SSD 7317 MODIFICATION 3 – RESPONSE TO SUBMISSIONS

This Response to Submissions report (RTS) is submitted to the (the Department) in support of Modification 3 to amend State Significant Development (SSD) consent SSD – 7317 relating to the construction of a commercial campus at the Australian Technology Park, Eveleigh.

1 URBAN FARM KITCHEN PLAN (4-05)
1 : 25

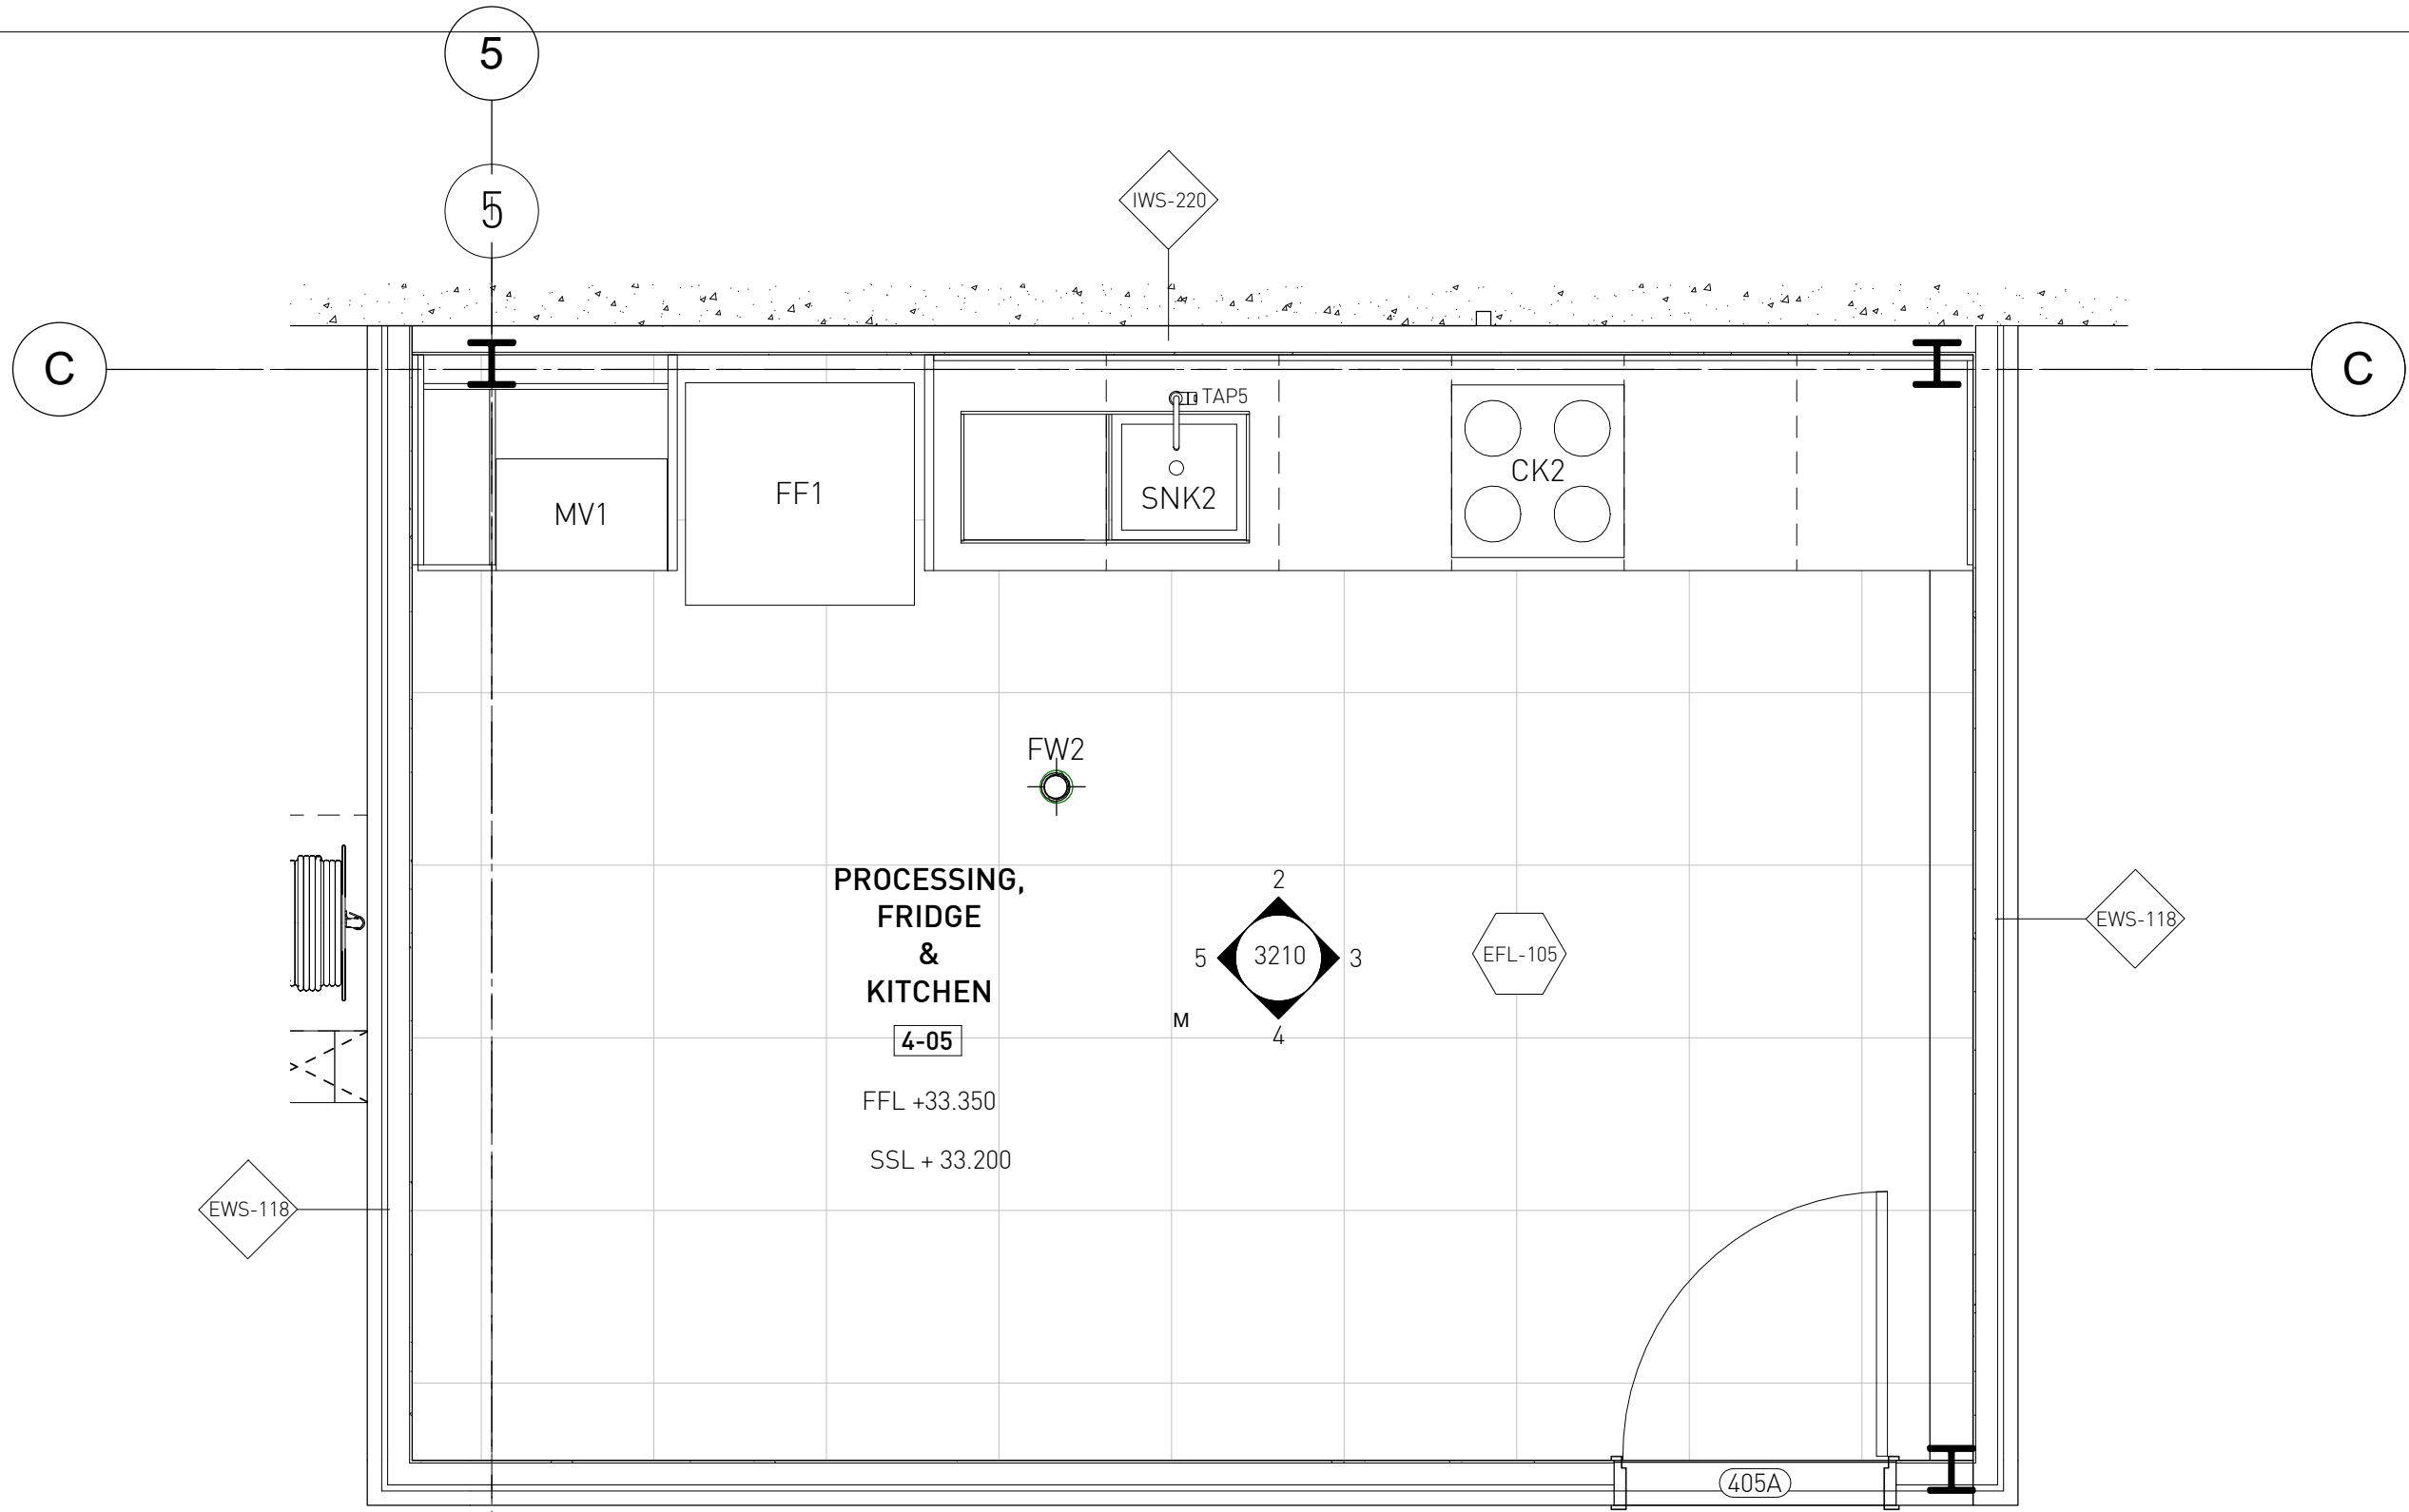
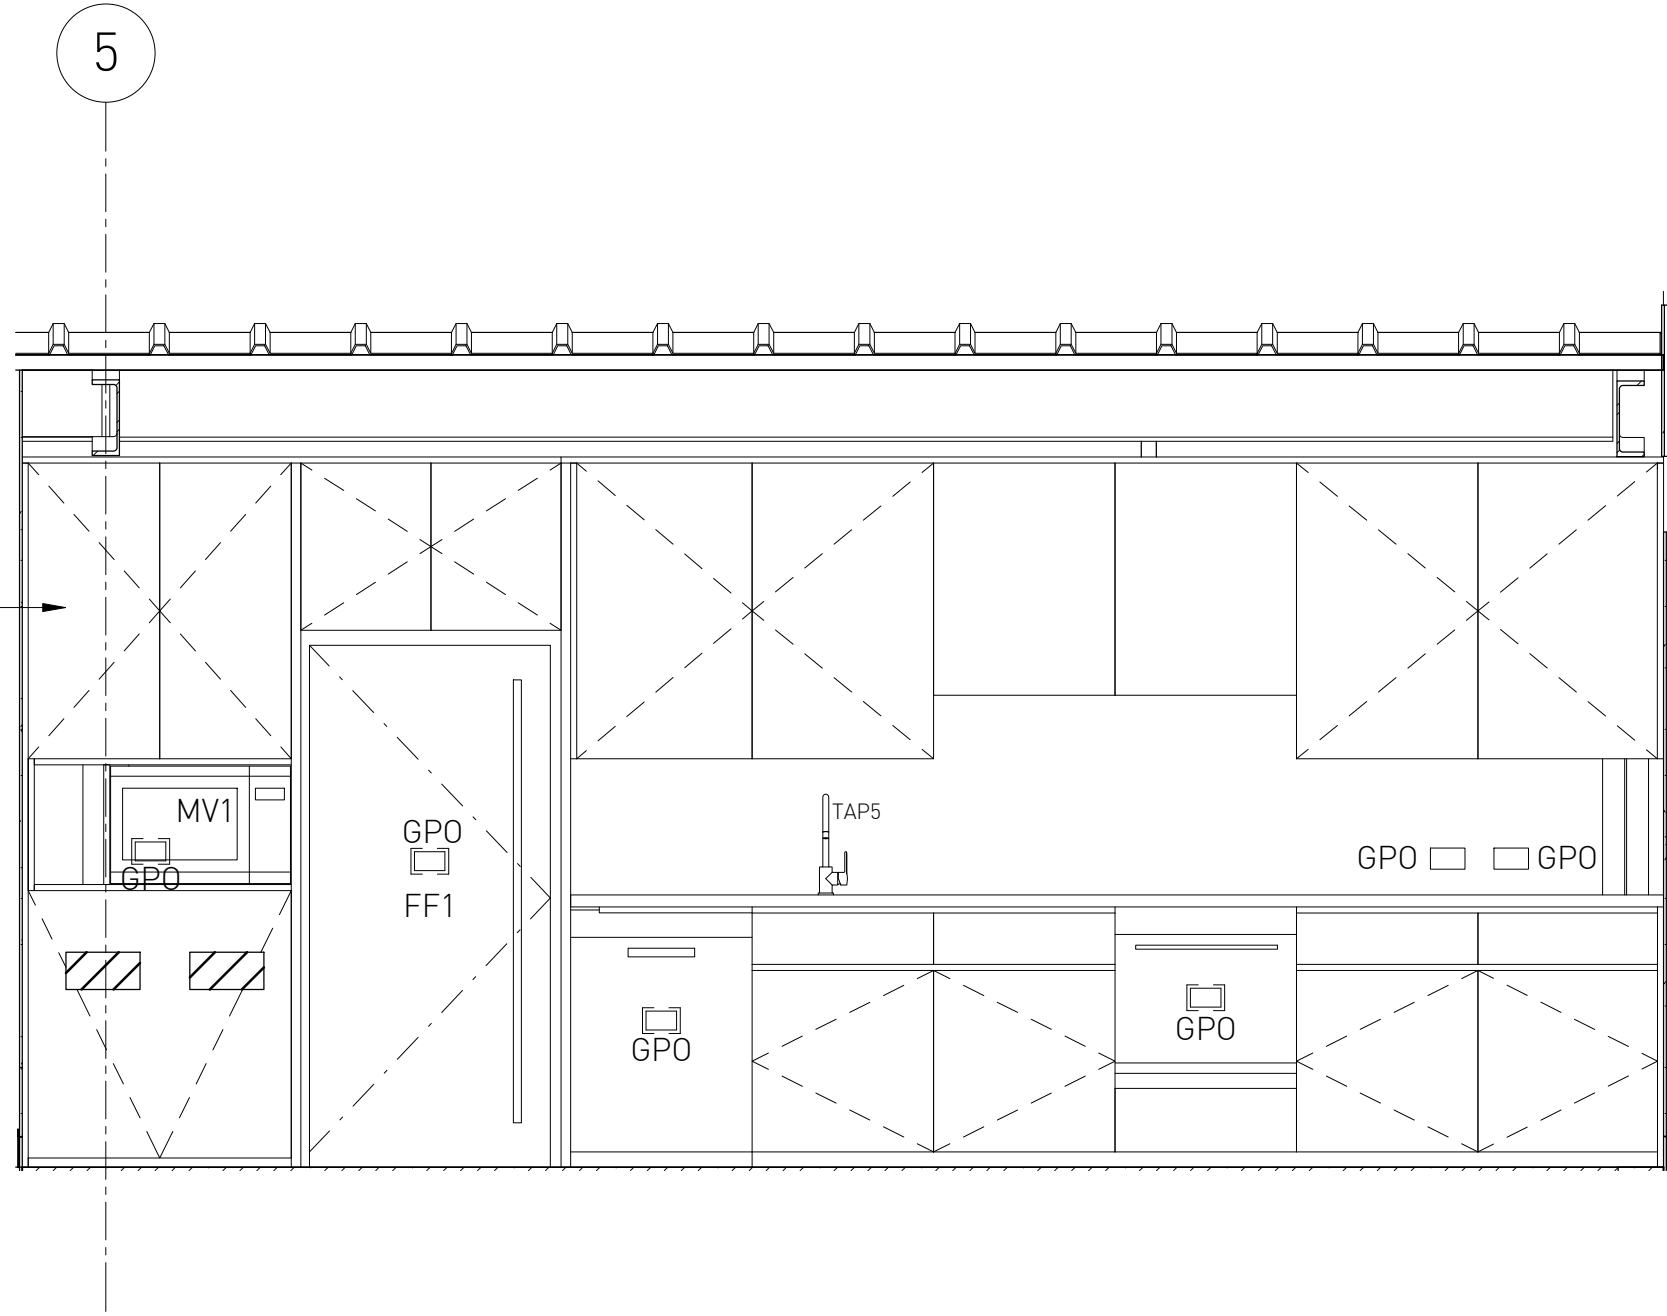
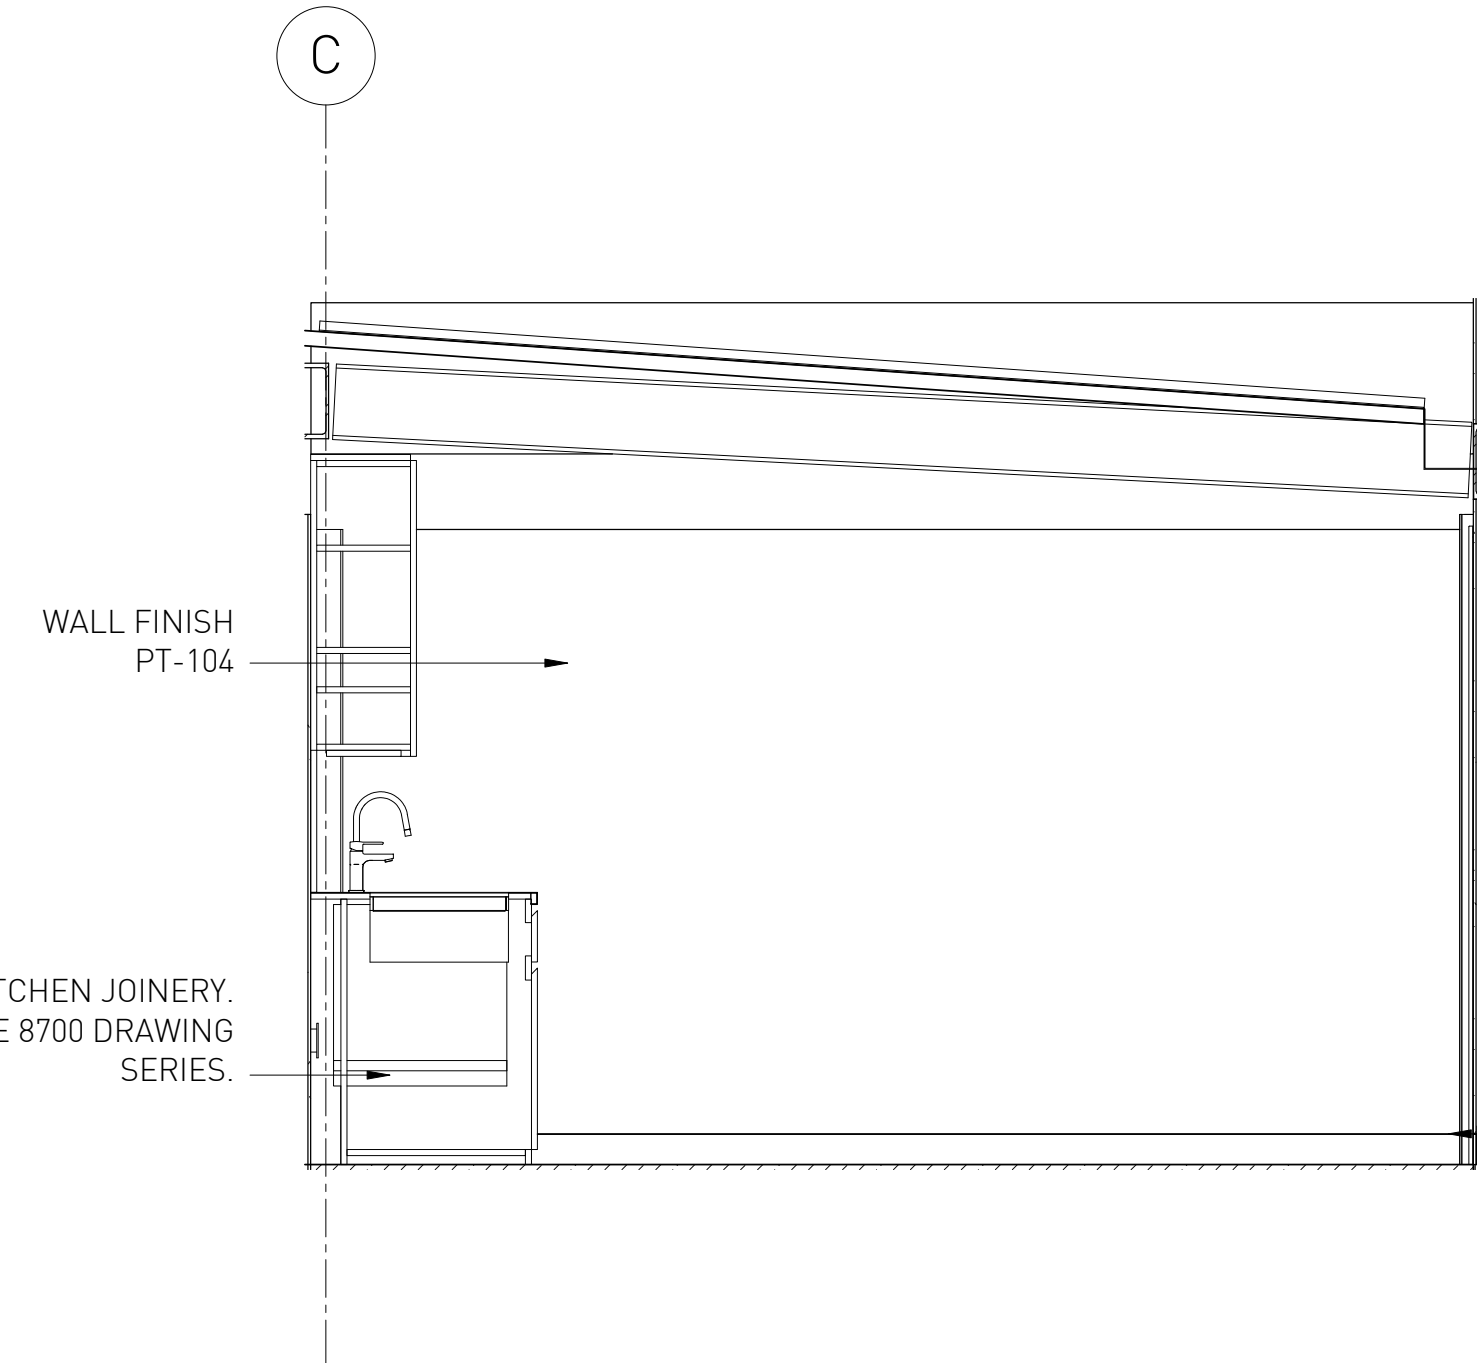
It is also noted that a rooftop kitchen is proposed. It is unclear what the purpose of the kitchen is and if food for sale (as defined by the Food Act 2003) is intended to be prepared there. If food for sale is prepared, the design and use of the kitchen must comply with the requirements the Food Act 2003

The rooftop kitchen is purely a reheat facility to allow the farm operator to facilitate small gatherings / events on the roof in association with the farm. It will not be used to prepare food for sale.
